REQUEST

Current Zoning: MUDD-O (mixed-use development-optional)
 Proposed Zoning: MUDD-O SPA (mixed-use development-optional, site plan amendment)

Approximately 1.23 acres located in the northeast quadrant of the intersection of Central Avenue and Morningside Drive, south of Roland Street.

The petition proposes to amend a previously approved plan permitting 44,000 square feet of nonresidential uses (with an allowed maximum of 24,000 square feet of retail and EDEE type uses) to increase total square footage to 45,000 square feet and allow residential as a permitted use.

RZP # 2022-224  
OFFICE AND RETAIL  
CENTRAL AVENUE AND MORNINGSIDE DRIVE  
2609 CENTRAL AVENUE

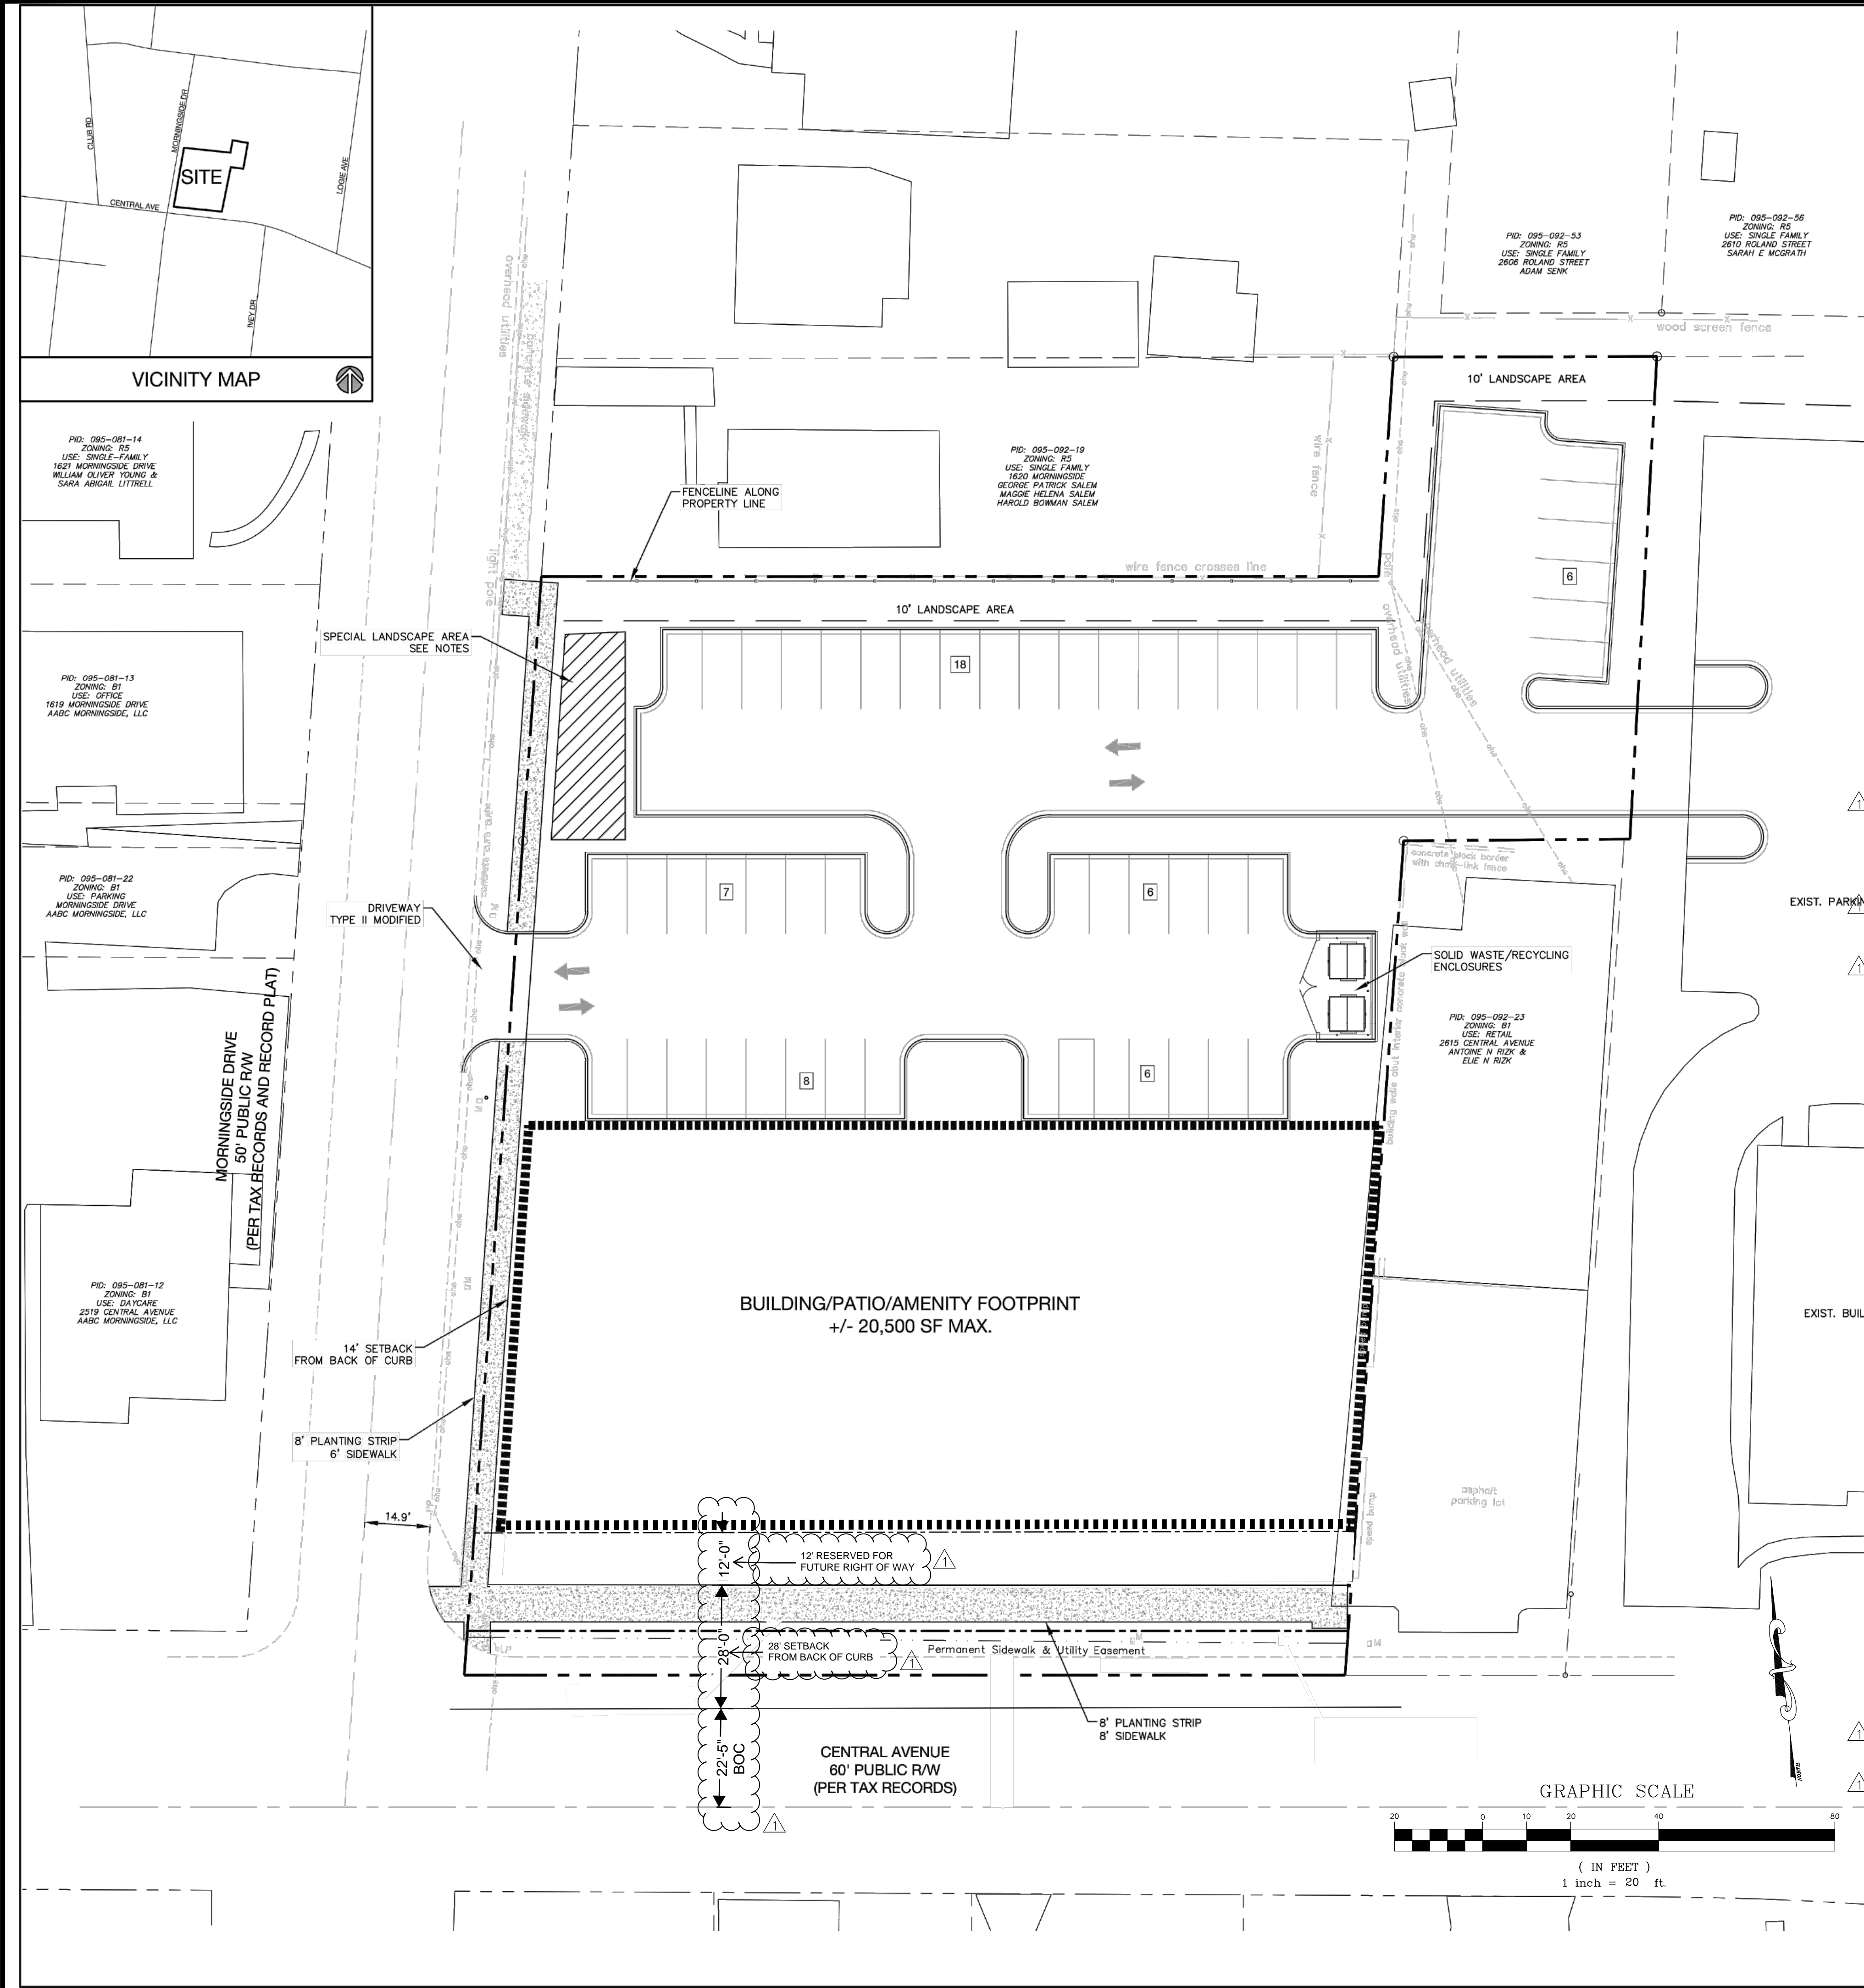
- a. ~~Central Avenue: Location of curb and gutter to be moved to 32.5 feet from roadway centerline to accommodate the Charlotte Streets Map with a roadway typical section of 4 Avenue with Buffered/Separated Bike Lanes.~~ **ADDRESSED**
- b. ~~Morningside Drive: The future location of curb and gutter is in its existing location.~~
NOTE: Additional distance from center line to back of curb may be required in locations where a median is present or around intersections and interchanges. **ADDRESSED**

~~Label and dimension the curb and gutter from the centerline for each road on the site plan.~~
ADDRESSED

3. ~~Revise site plan and conditional note(s) to commit to dedicate 50.5 feet of right of way from the Central Avenue Road centerline. The site plan shall label and dimension the right of way from the road centerline. **Comment 11-27-23:** Please add a label and dimension showing right of way dimension mentioned on site plan and revise conditional note(s) to commit to previously mentioned right of way dimension. **Clarifying comment 11-07-24:** Add dimensions from the roadway centerline to ROW along both frontages. - **ADDRESSED**~~

4. ~~Add a conditional note specifying "the Petitioner shall dedicate and convey in fee simple all rights of way to the City before the site's first building certificate of occupancy is issued. CDOT requests rights of way set at 2' behind back of sidewalk where feasible." **Comment 11-27-23:** Please add the above conditional note. **Clarifying Comment 11-07-24:** Add "before the site's first building certificate of occupancy is issued" to note G under Streetscape and Landscaping. **ADDRESSED**~~
